**Consultation Response from Mike Hibbert,
KC Waste Strategy(Refuse & Recycling)**

2023/92966 Land to the rear of, 271, Cliffe Lane, Gomersal, Cleckheaton, BD19 4SB

Demolition of existing dwelling and erection of 87 dwellings including formation of a new access from Cliffe Lane, landscaping, public open space and all associated infrastructure and engineering works

Responding Ref: WPN 23-055

CLIENT	QUARTERS GOMERSAL
PROJECT	CLIFFE LANE, GOMERSAL
TITLE	SITE PLAN LAYOUT
DRAWING NO.	1694-101
REVISION	F
SCALE	1:500 @ A1
DATE	01.23
DRAWN BY	BC
CHECKED BY	-

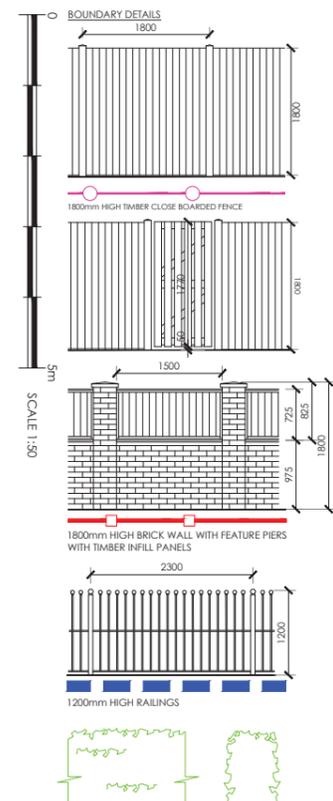
- It is noted that Plots 65 to 69, 70, 75 to 78 and 84 to 87 have bin storage to the front of dwellings due to the topography of the site. This is acceptable, but bins should not be located under windows/ next to doors. Wheeliebins located at the front of properties will be set within the Streetscene and therefore should be screened and secured to prevent bin blight, the spread of waste into the street, unauthorised use and theft/damage to bins.

- Plot 80 is in the middle of a block of three properties. The access from the rear garden has a convoluted pathway routed across the back of Plot 79. As this can discourage residents from returning bins to the rear, resulting in bin blight in the Streetscene it may be more appropriate to have a bin store at the front of the property.

- The Authority will not take an RCV into private drives or roads that are not built to adoptable standards as those shown outside Plots 2 -3, between Plots 22 and 24 and between 52 and 56. On this basis Plots 2-3, 24-28, 33-43, 66-69,76-78 will need communal presentation points for bins. These must be large enough for the number of bins to be collected and be on level, hard surfaces such that grouped bins do not cause obstruction to the highway, drives or pedestrian movement on collection day. Details on the specification and dimensions of storage and presentation points can be found in the Kirklees Waste Management Design Guide 2020.

- The layout plan shows the location of bin collection points (BCP's) for presentation of wheeliebins. Bin Collection Points must be located no more than 25m from the curtilage of the property in accordance with Building Regulations 2010 Part H section 1.8. and in guidance BS5906:2005. The distance from the BCP to the adopted highway should be a maximum of 10m.

- Plots 2 and 3 require identification of a BCP adjacent to the adopted highway. The distance from Plot 2 to the adopted highway is approximately 15m so within guidance distance.

- Plots 24 to 28 are on the limit of the drag out distance of 25m to the BCP with then 8m to the adopted highway.
- Plots 52 to 56 are located on a private drive. The BCP is shown next to Plot 52. The drag out distance from the properties to the BCP is acceptable but the BCP is in excess of 8m from the highway. Relocation of the BCP next to the highway will make the drag out distance from Plots 52 and 56 still under 25m. Plots 53,54 and 55 would be in excess of the limit specified in guidance, this however would be preferable solution without relocation of the properties.

- **The WCA has a strong preference for Looped Road layouts. Although there may be some constraint due to the gradient, it would be welcomed if site road adjacent to plots 11 and 34 could be connected and this would remove the requirement for a turning head between plots 5 and 6.**

- The proposed road layout includes turning heads between plots between Plots 5-6, 71-72 and 81-82. The turning facilities must be demonstrably sufficient for an 11.22m refuse collection vehicle and opportunities for parking in the turning areas must be designed out. Swept path analysis must show the manoeuvrability of this vehicle throughout the site, demonstrating the safe passing of other vehicles likely to be using the road – either parked or moving.

- Parked cars are a perpetual problem for RCV access and as such it is important to account for potential parking spaces, even where these are undefined when assessing RCV access around the site. As the turning head between Plots 5 and 6 is not visible from the entrance to this portion of the development, if the turning head is blocked by parked cars this would require a long reversing manoeuvre. **The Waste Industry Safety and Health (WISH) Forum guidance states “Reversing causes a disproportionately large number of moving vehicle accidents in the waste/recycling industry. Injuries to collection workers or members of the public by moving collection vehicles are invariably severe or fatal. BS 5906: 2005 recommends a maximum reversing distance of 12 m.”**

- The site roads serving Plots 11-22, 70-78 and 83-87 are shown as being surfaced with block paving. Confirmation is sought that all roads will be constructed to adoptable standards with dimensions/ sweep path analysis that will accommodate an RCV.
